May 7, 2020

SUBJECT: SF-19-018 – Branding Iron at Sterling Ranch Filing No. 2 - Response Letter

LANDSCAPE PLAN

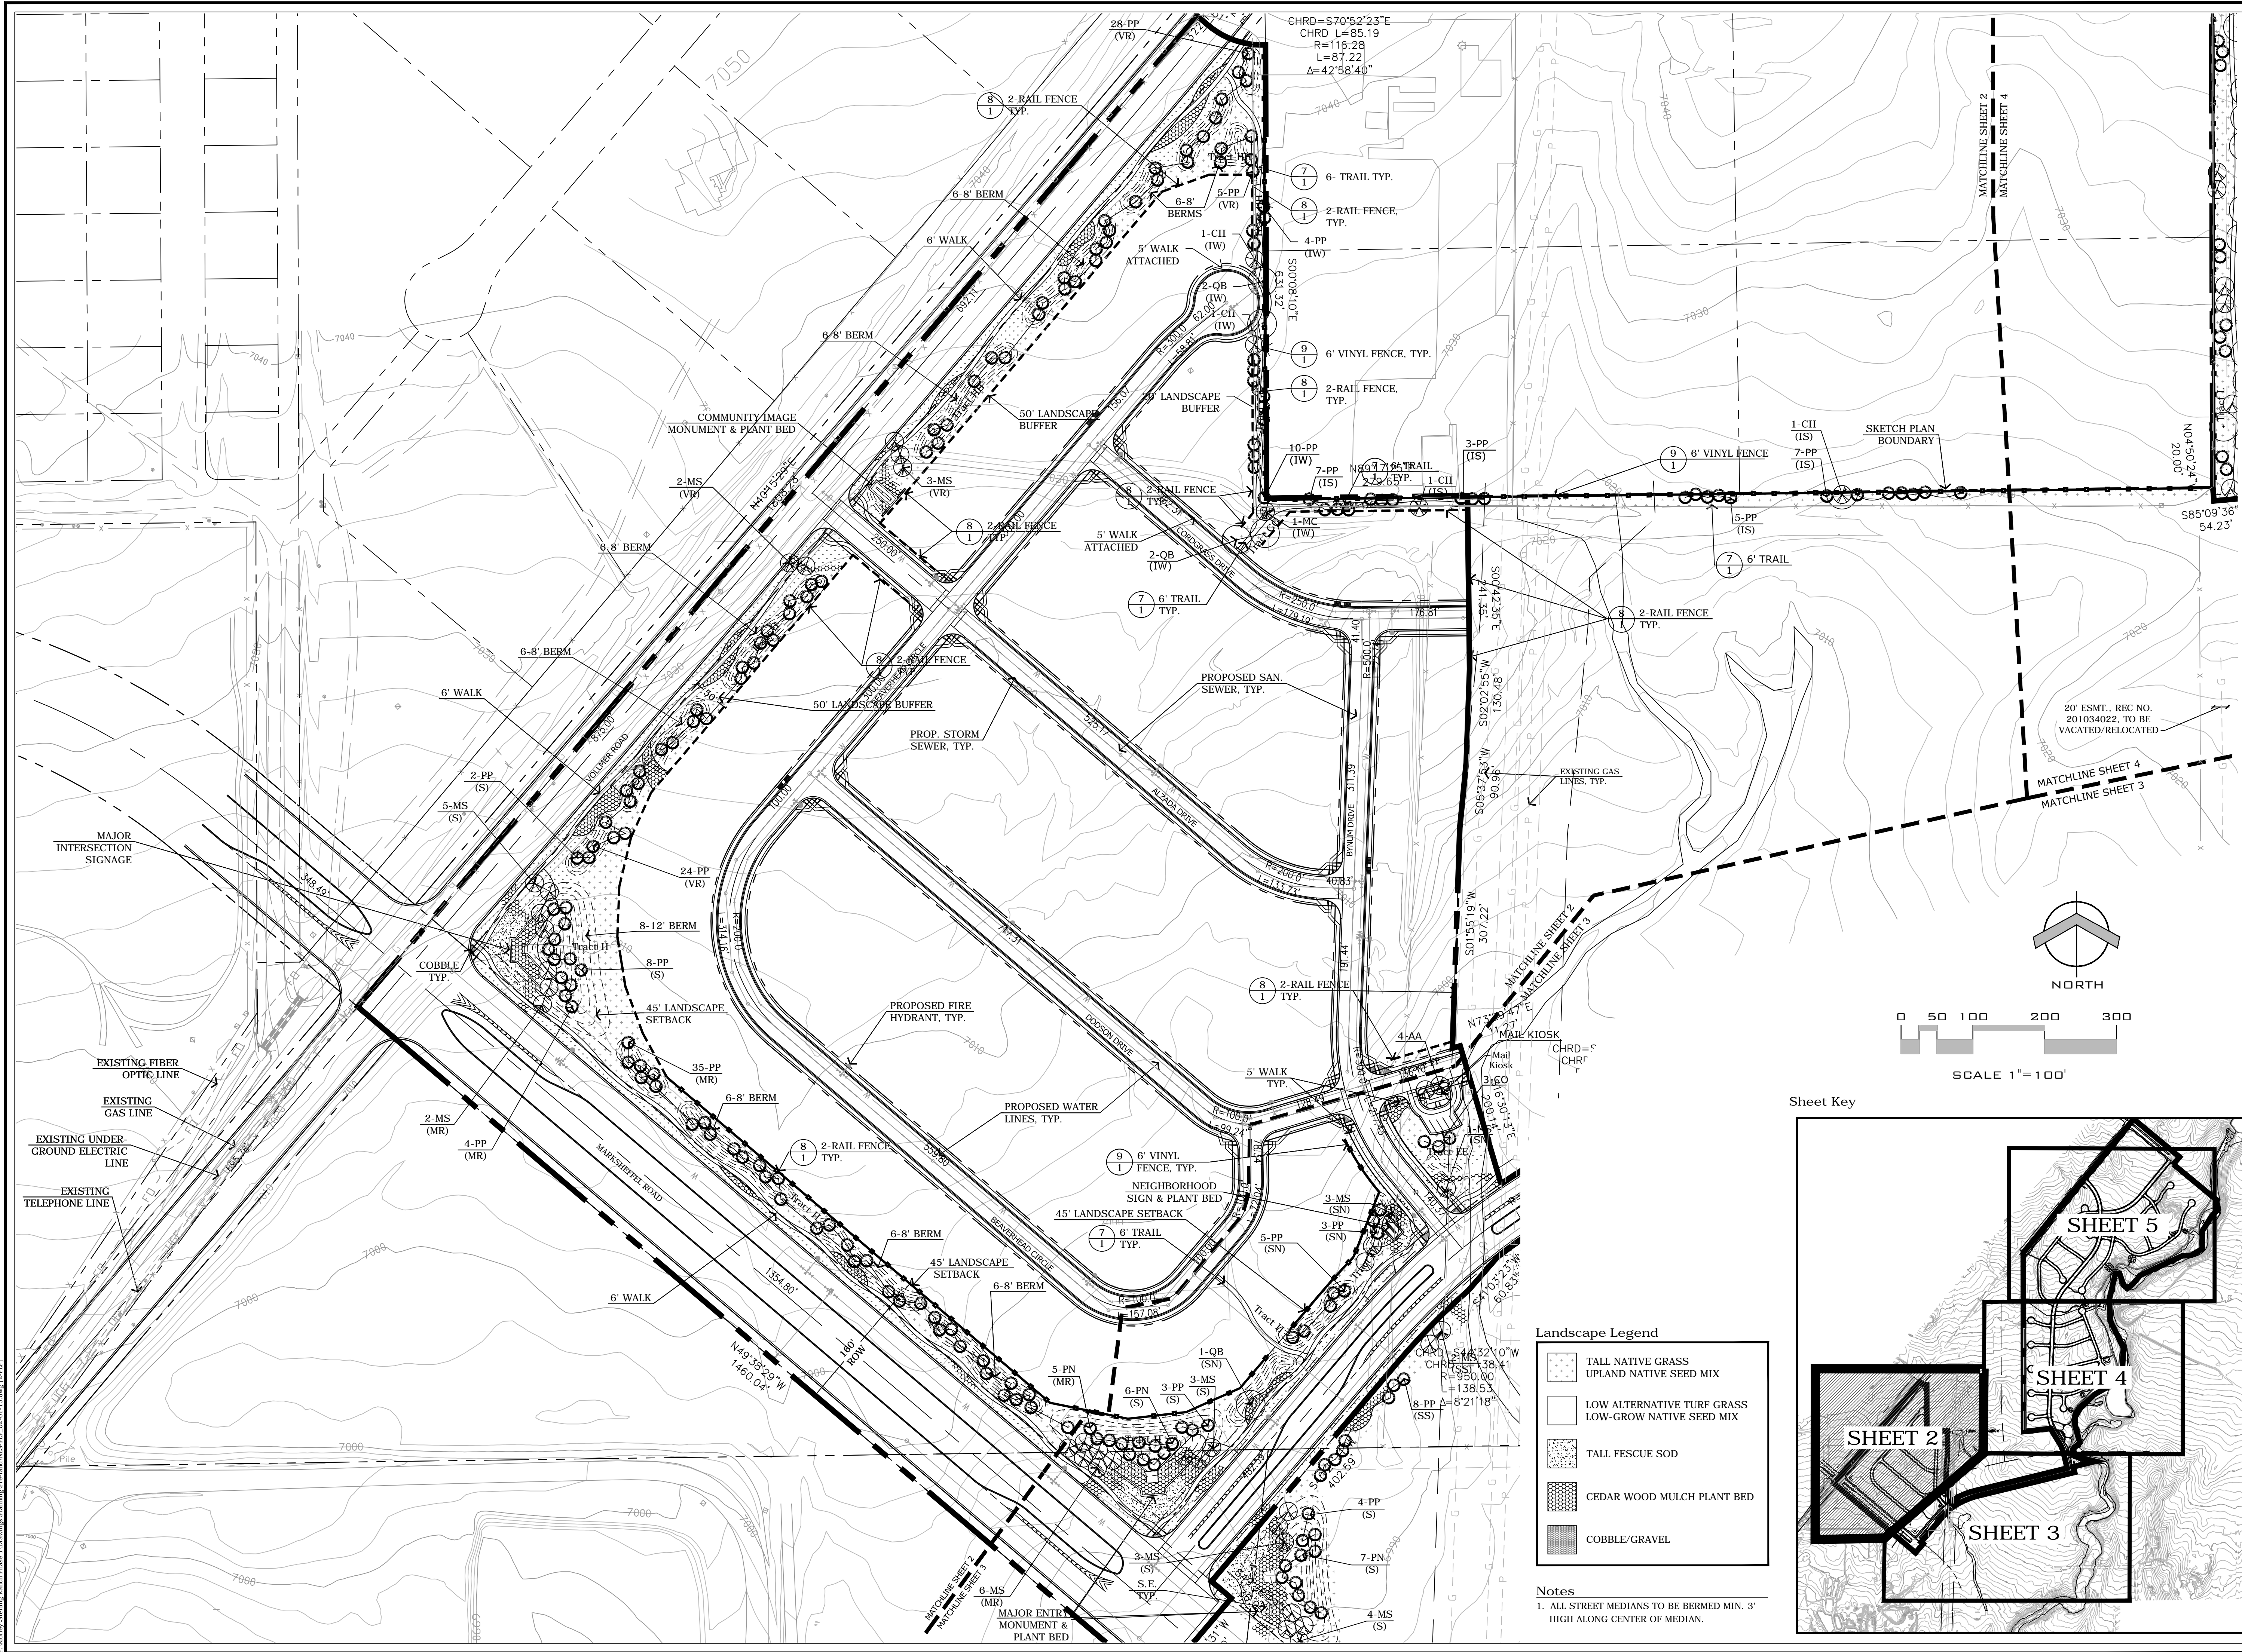
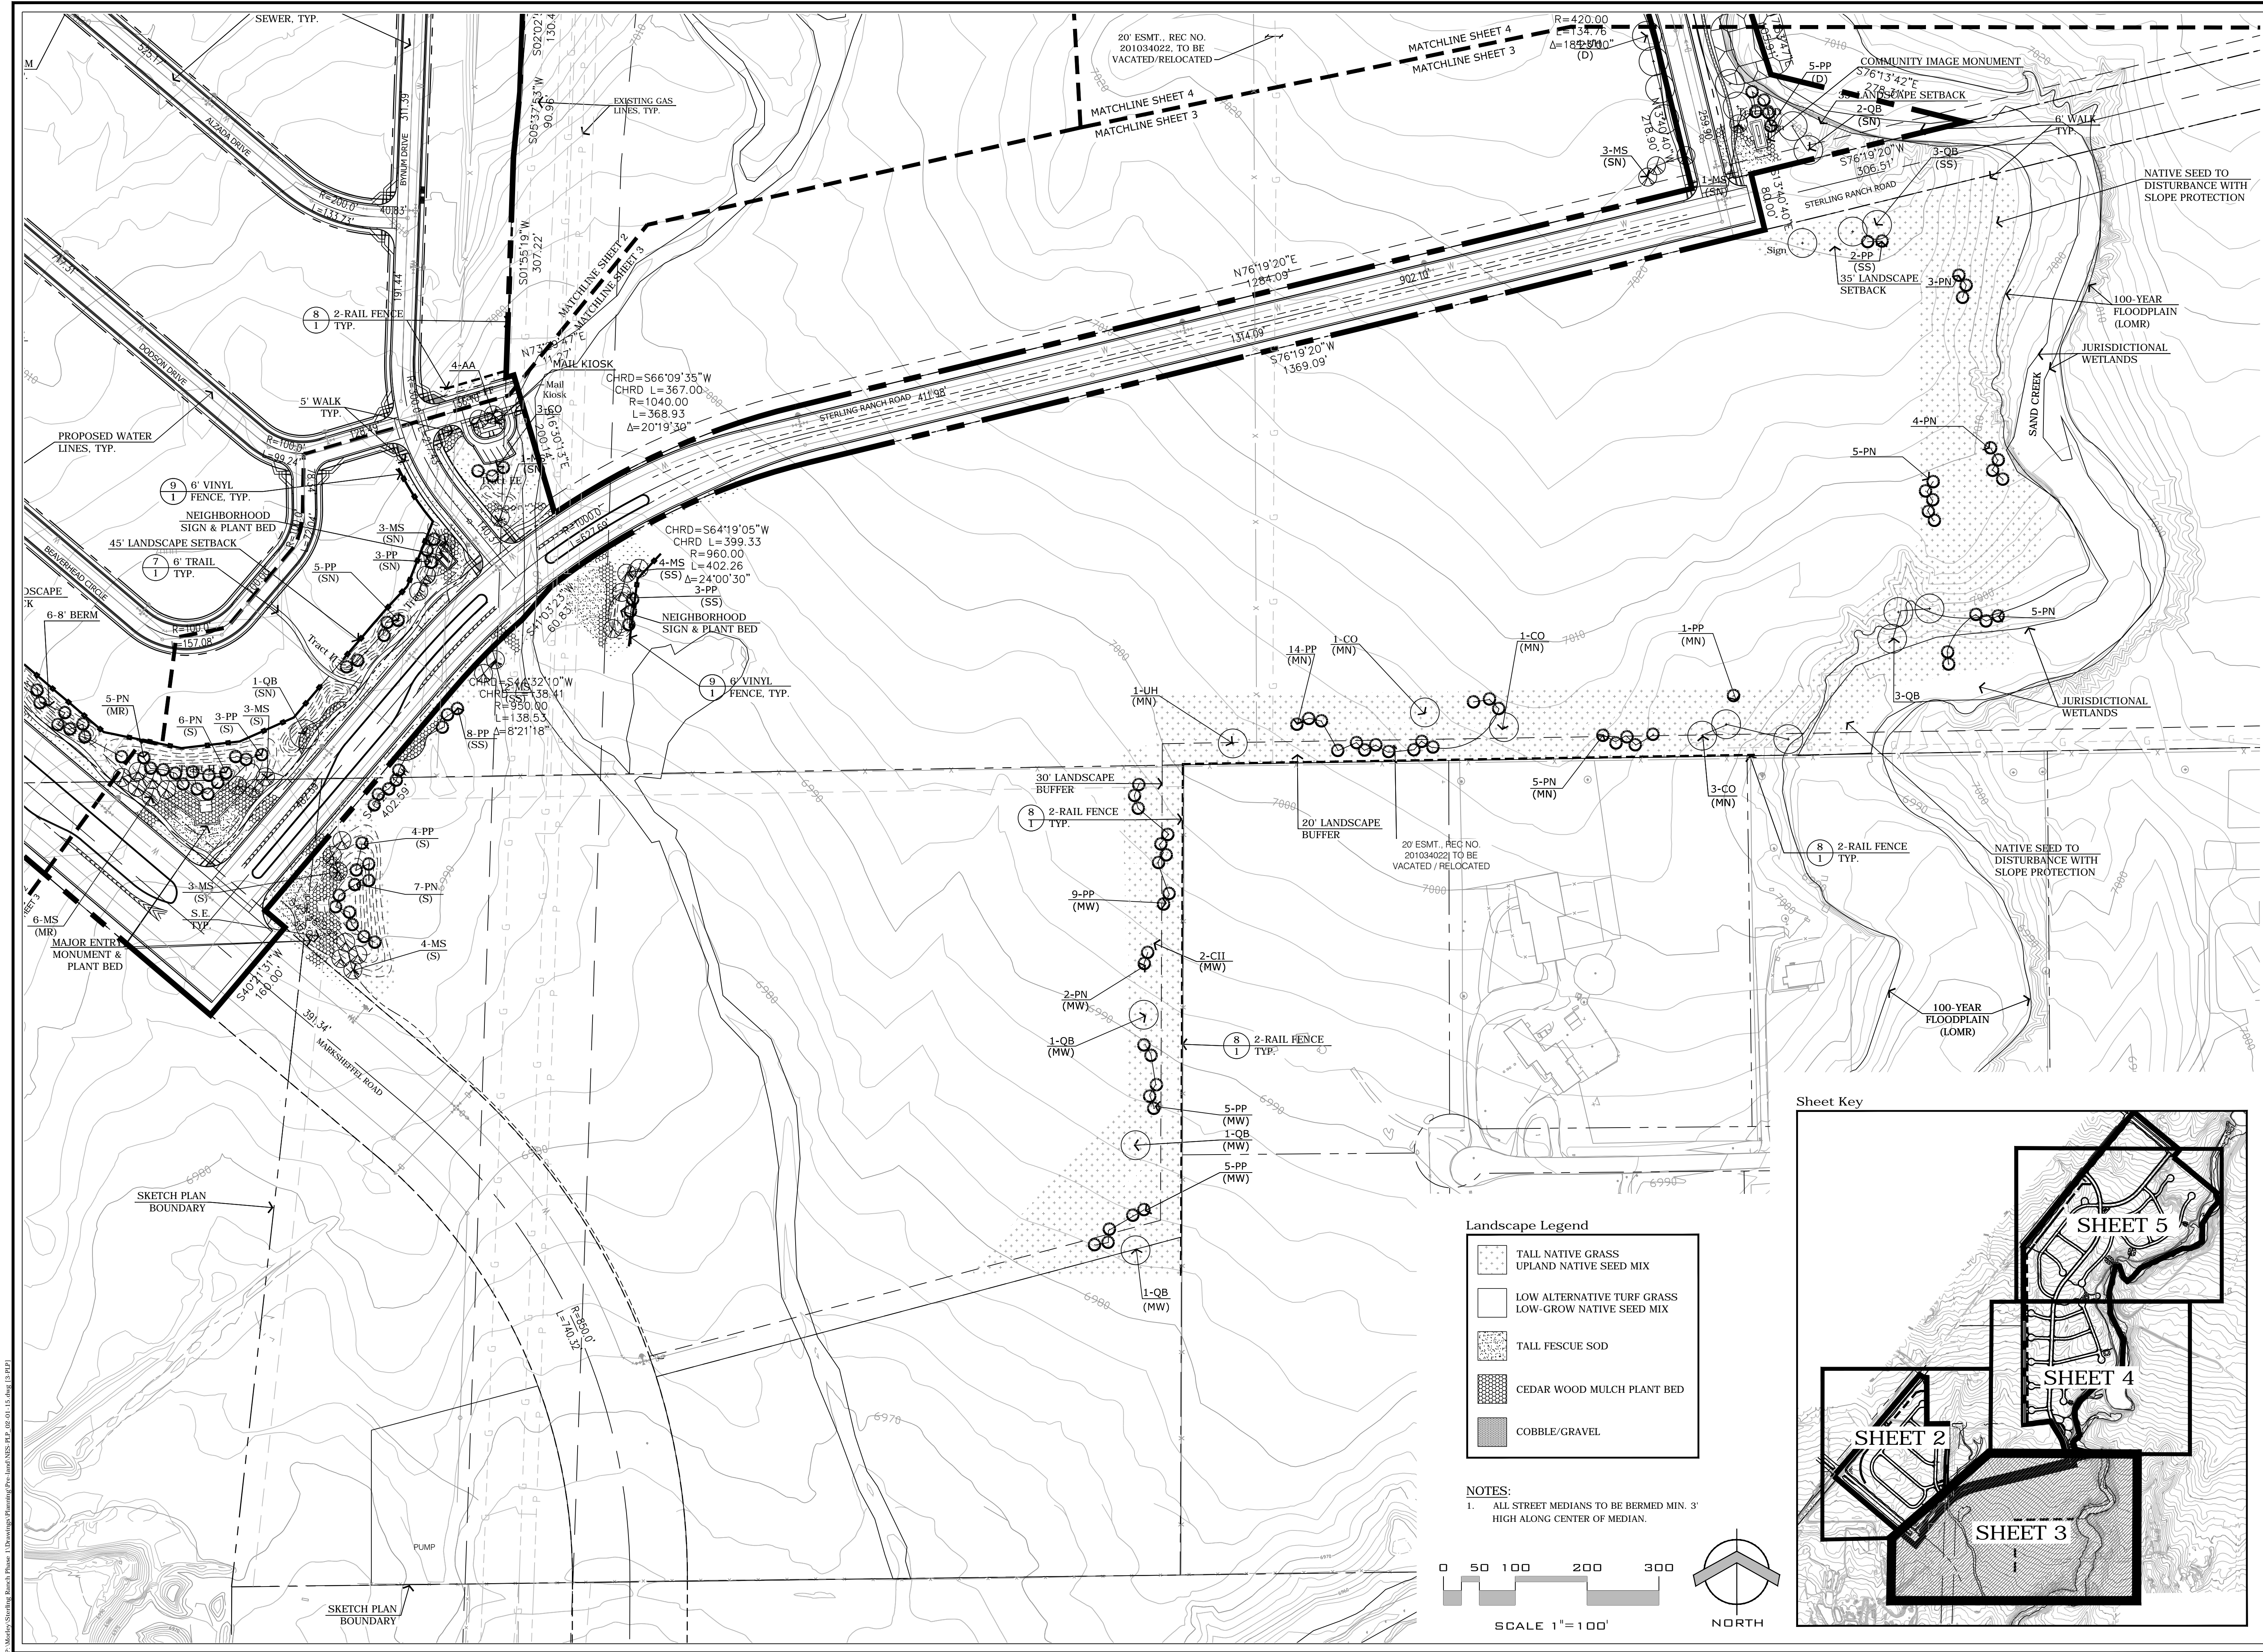
8. **The landscape plan submitted is illegible. NES will submit a legible plan for this project.**
